WEST SUSSEX COUNTY COUNCIL CONSULTATION

TO:	Arun District Council FAO: Michael Eastham
FROM:	WSCC - Highway Authority: Tim Townsend
DATE:	29 October 2020
LOCATION:	Land south of Ford Lane East of North End Road Yapton BN18 0DS
SUBJECT:	Y/105/20/DOC Approval of details reserved by condition imposed under Y/80/16/OUT relating to condition 10- Construction Method Statement. More information received.
DATE OF SITE VISIT:	19 October 2020
RECOMMENDATION:	More Information Required
S106 CONTRIBUTION TOTAL:	n/a / £ See below for breakdown.

This is the second WSCC County Highway Authority (CHA) response to the above planning application for approval of details reserved by condition imposed under Y/80/16/OUT relating to condition 10 - Construction Method Statement (CMP). Previous CHA comments were made in response dated 19th October 2020.

FORD LANE YARDON
CONSTRUCTION PHASE PLAN

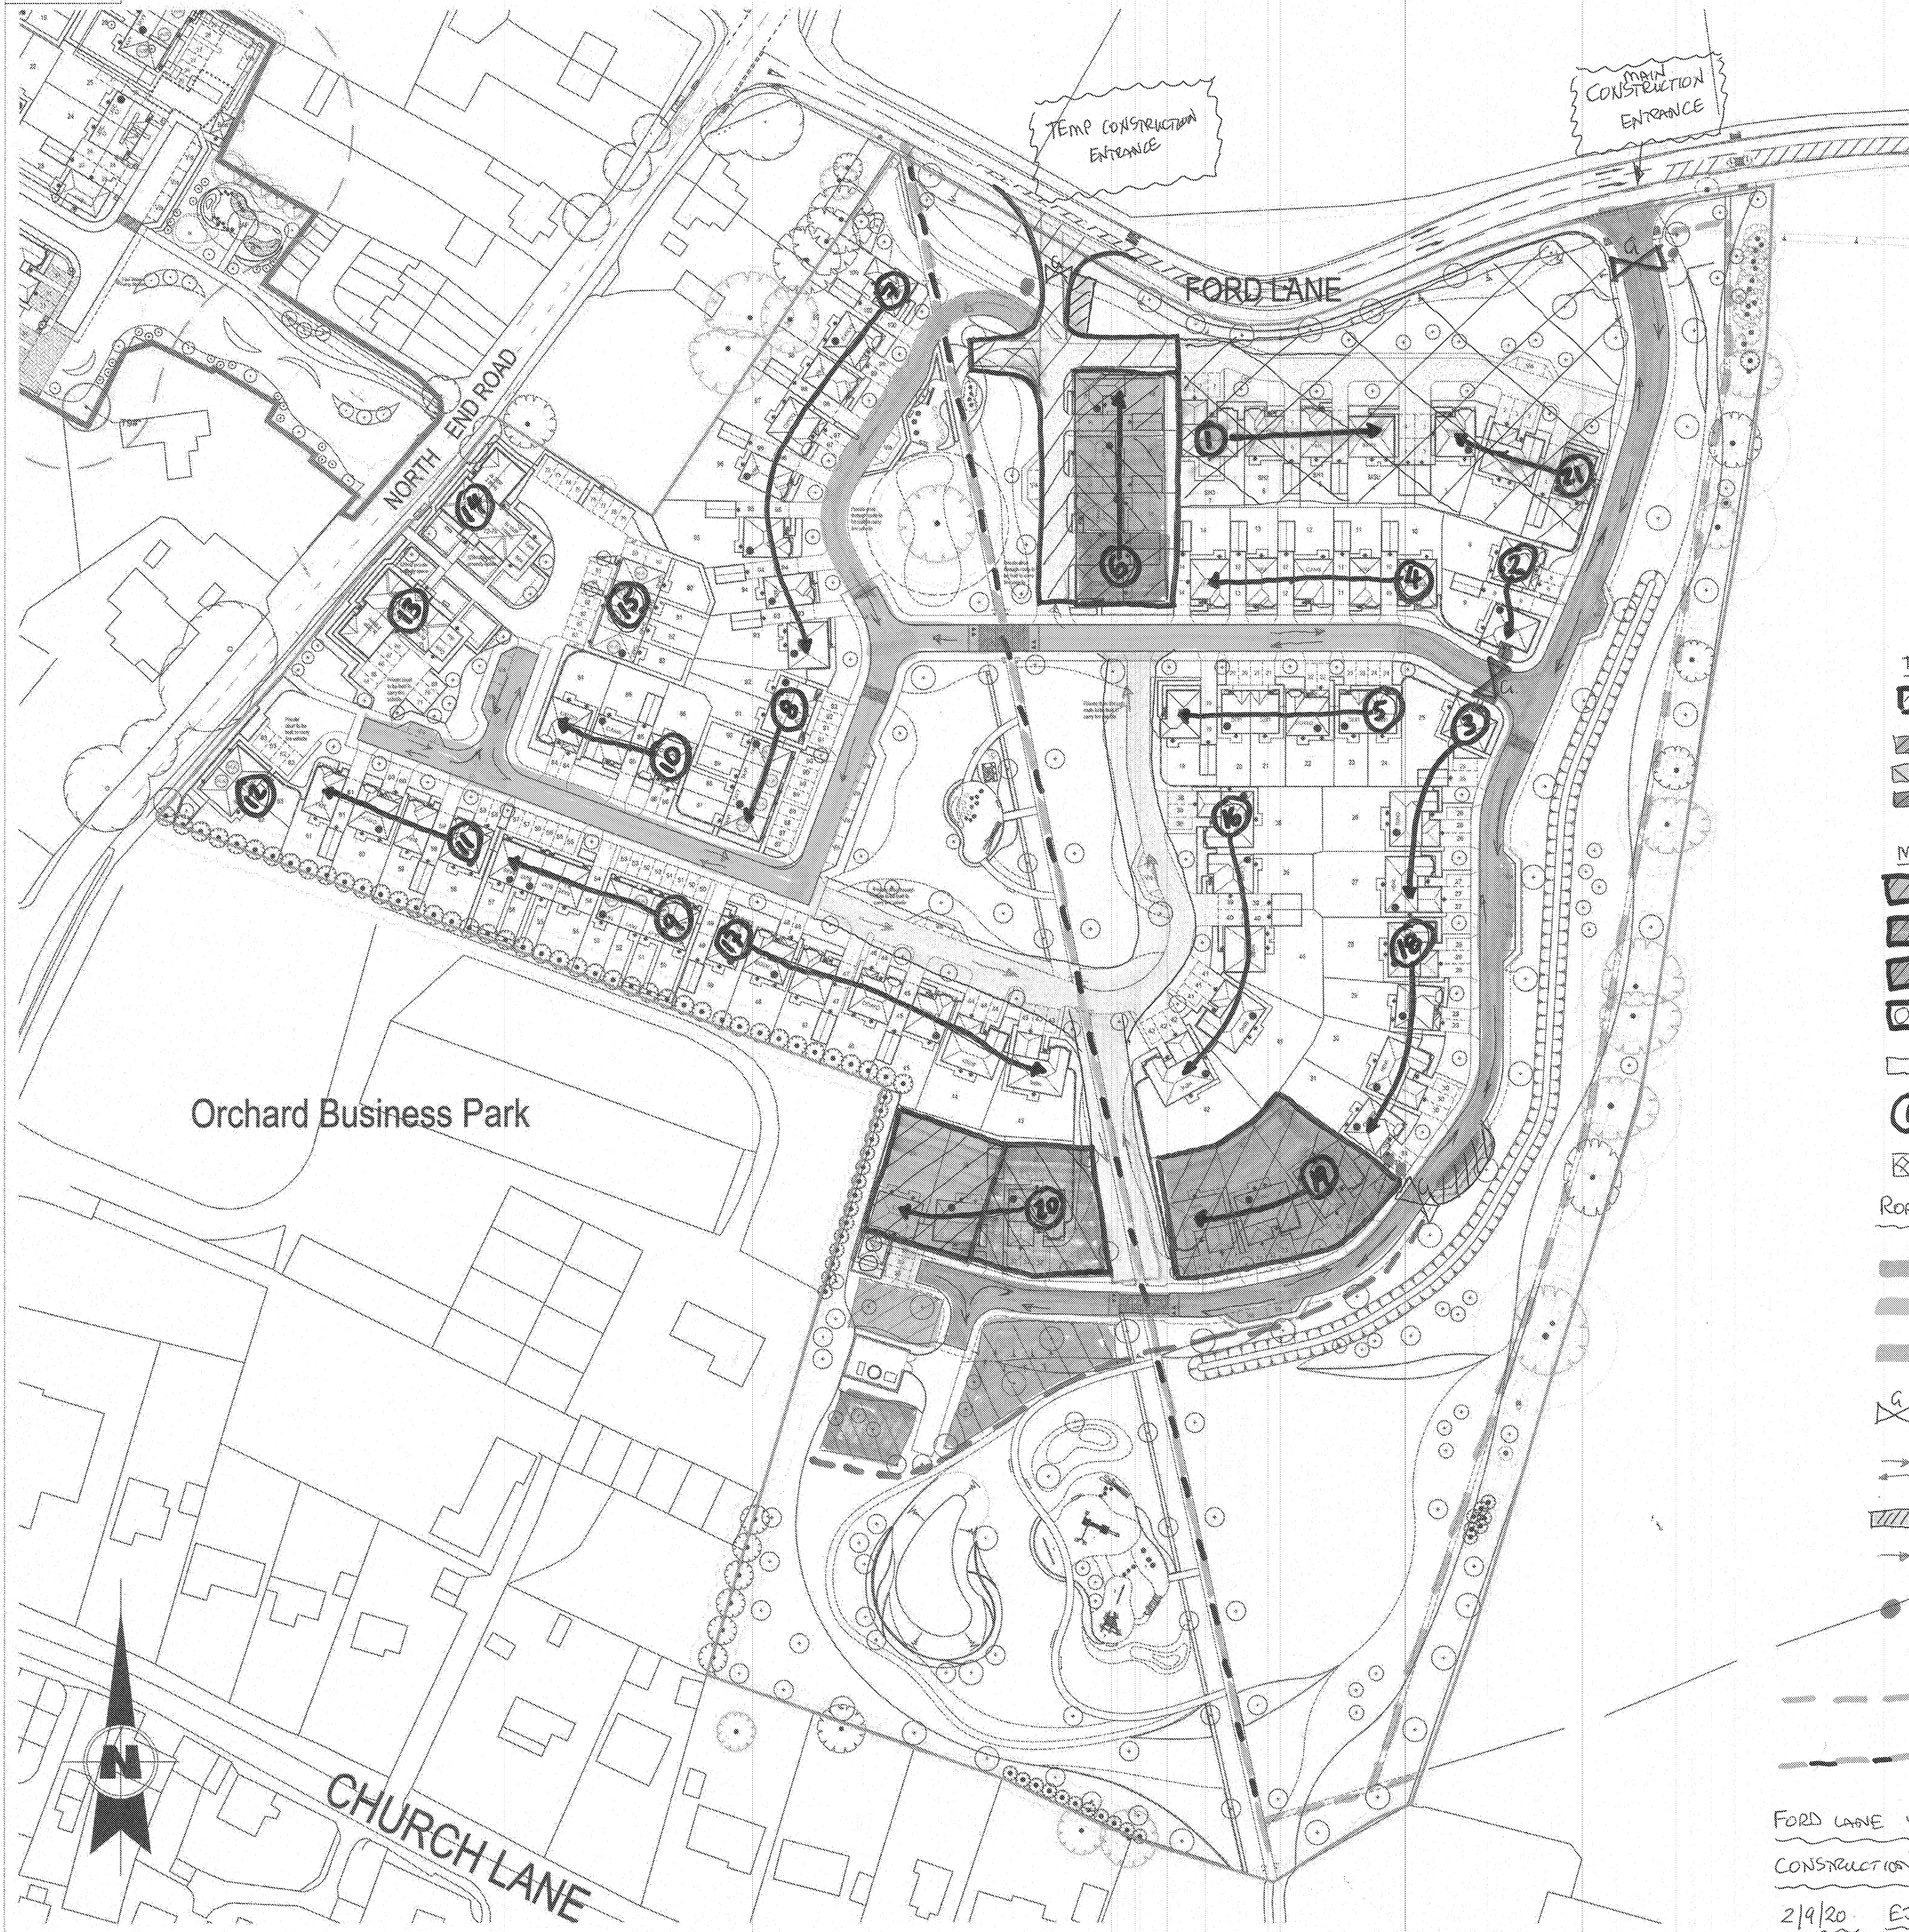
The CMP refers to a temporary site entrance and includes a plan showing the indicative location of it. However, no detailed plans are provided nor is it stated why this access is required (*the latter information is still required*). As such, the application should provide this additional information, including a Stage 1 Road Safety Audit plus any other supporting information, including the duration of time that the temporary access is required for.

A plan and Stage 1 Road Safety Audit have been provided (please see Drawing No. 18-344/701 Revision 'A' dated August 2020 and Road Safety Audit Stage 1/2 'Temporary Construction Access' prepared by M&S Traffic Ltd. dated 22 September 2020). However, it is not explained why a separate construction access is required. With regard to the Road Safety Audit, this raises a number of points that the CHA considers are not addressed in the accompanying Road Safety Audit Log (Designer's Response) - the latter document prepared by Odyssey Transport Consultants dated 25 September 2020.
